CLOVERLEAF SUBDIVISION

LOCATED IN THE NORTHEAST QUARTER OF SECTION 23 AND THE NORTHWEST QUARTER OF SECTION 24, TOWNSHIP 11 SOUTH, RANGE 67 WEST OF THE 6TH PRINCIPAL MERIDIAN, COUNTY OF EL PASO, STATE OF COLORADO
PRELIMINARY PLAN

PRELIMINARY PLAN

PRELIMINARY UTILITY PLAN

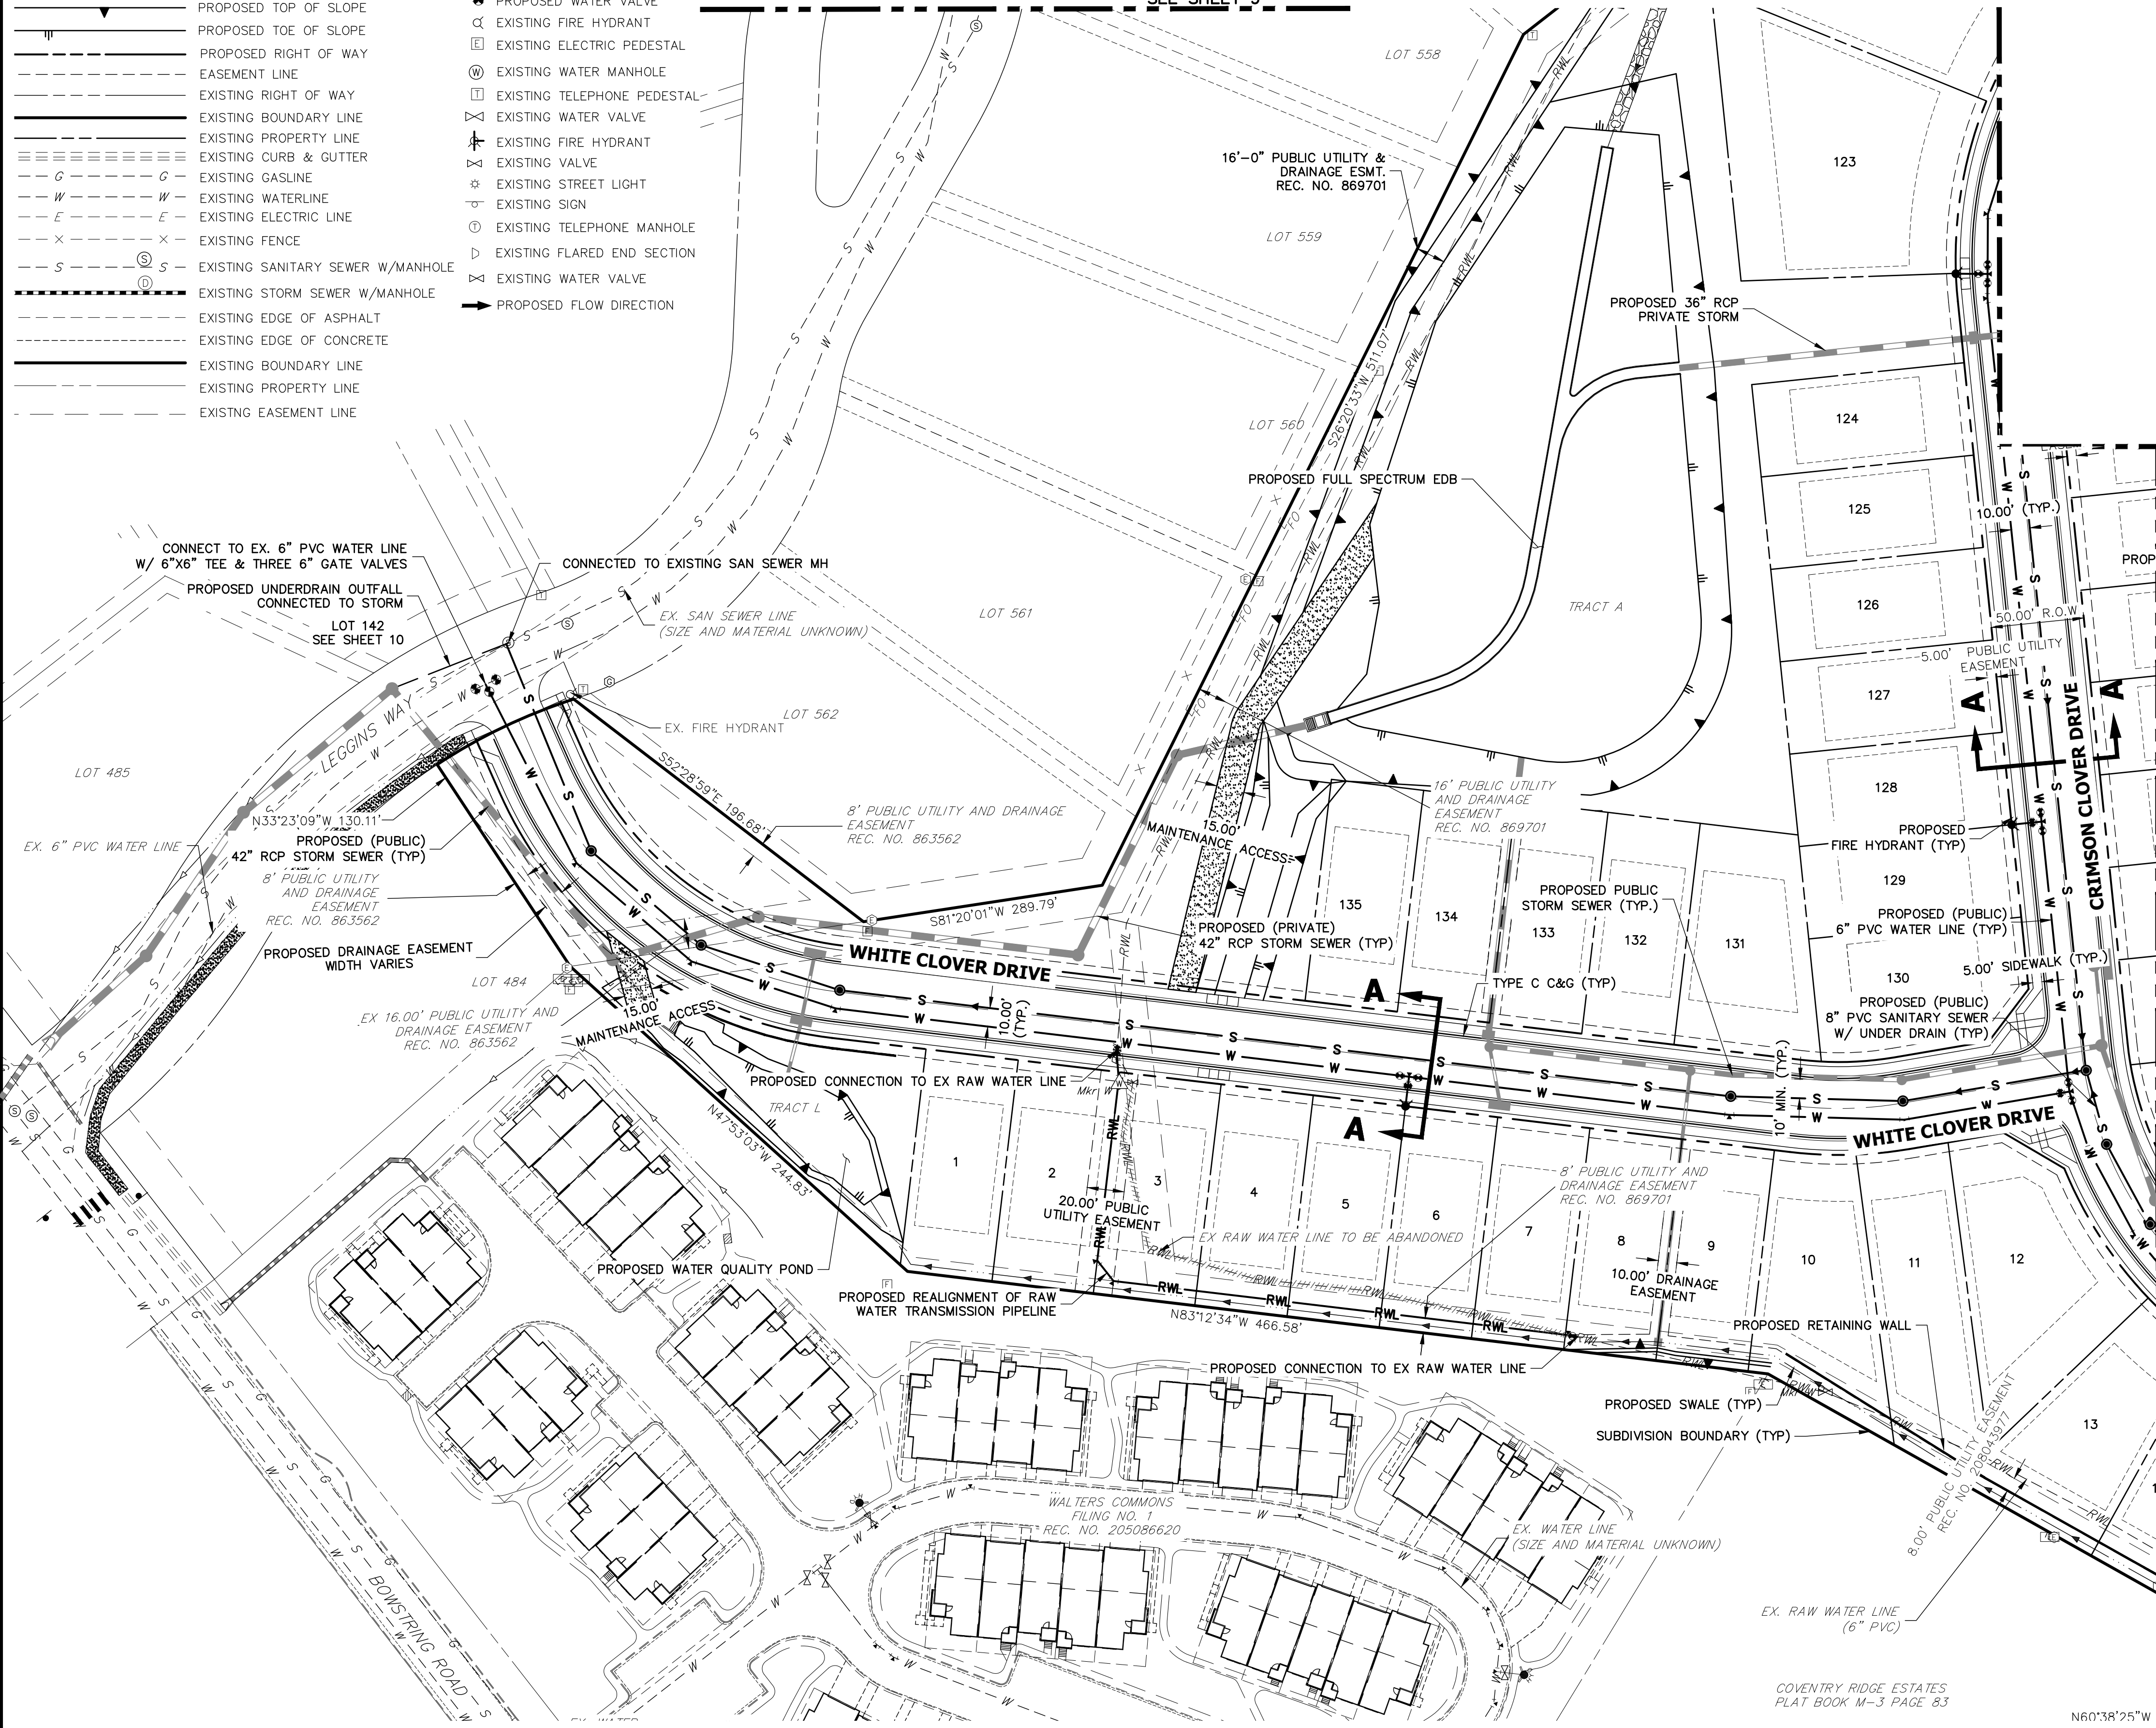
Remove. This section has been revised to a standard urban local road cross section.
